AB/120/20/PL & AB/121/20/L

Old Bank House 1 High Street Arundel BN18 9AD

Change of use of existing building from office (Use Class B1a) to residential dwelling (Use Class C3) with minor internal layout changes. This application affects the setting of listed buildings, affects the character & appearance of the Arundel Conservation Area

PROPOSED FIRST
FLOOR PLAN
(1:50)

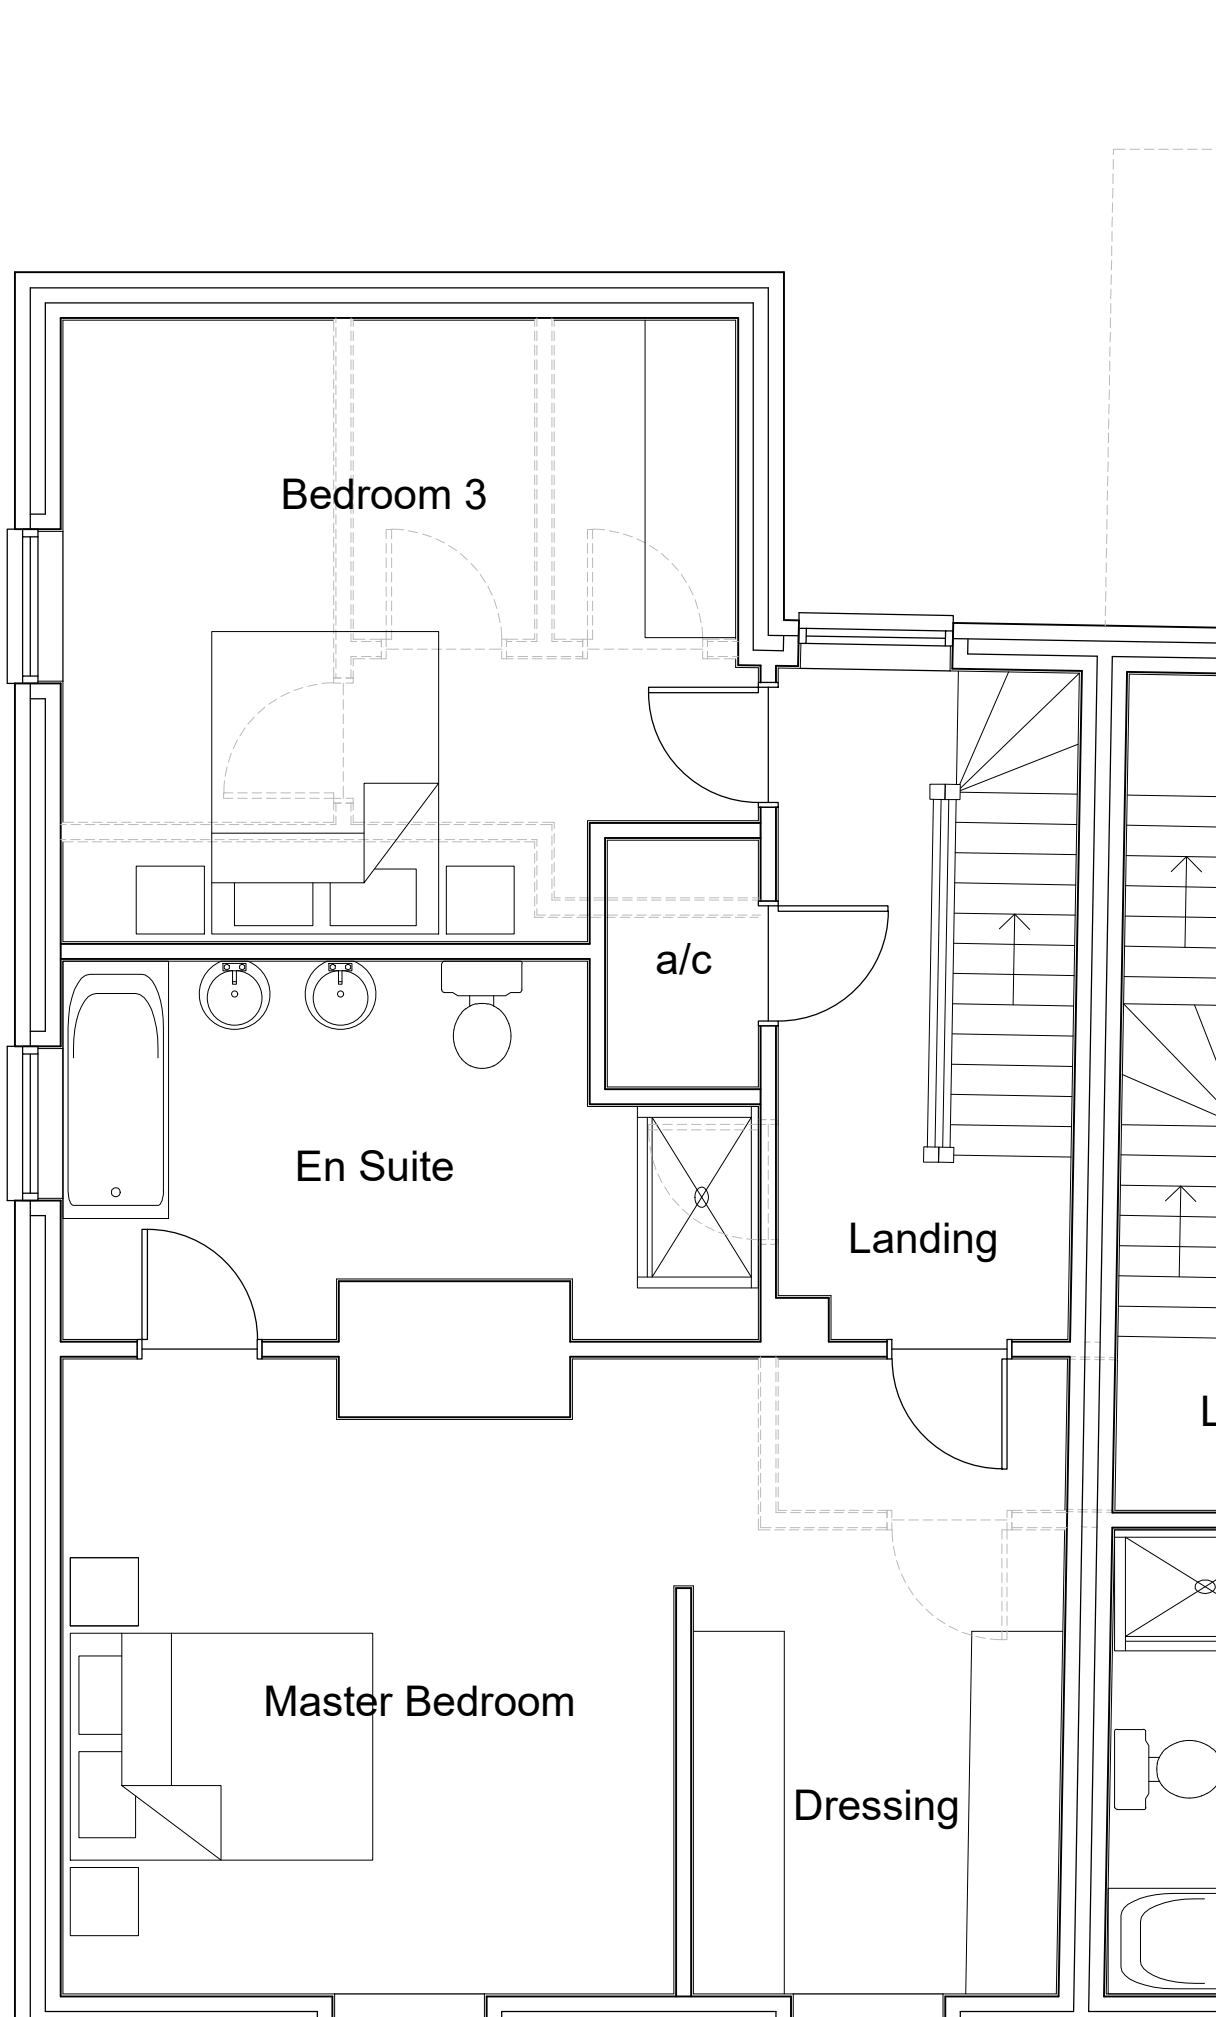
When reviewing the plans provided it is clear that a number of internal alterations are required including the relocation of walling and the introduction of new kitchen and bathroom facilities. Reference is also made to the fact that there has been a considerable amount of modernisation to the interior of the building, including the introduction of fire doors. It is not clear if these fire doors are to be replaced, and if they are, what with? The loss of modern material is acceptable, especially if it is to be replaced with something more in keeping with the age and style of the building. Details of the internal joinery such as doors and skirting boards etc. could be provided for by way of condition, if you are minded to approve the application. The relocation of some internal walls are of a scale which will not harm the significance of the building.

The introduction of new bathrooms and kitchen would be into rooms currently used as offices and will require the introduction of new plumbing/electrics into these spaces. It is not clear how the drainage will be dealt with from these new rooms. It should not be via the elevations which present themselves to the public domain. Likewise, care must be taken when installing new pipework and cables so that limited historic fabric is lost.
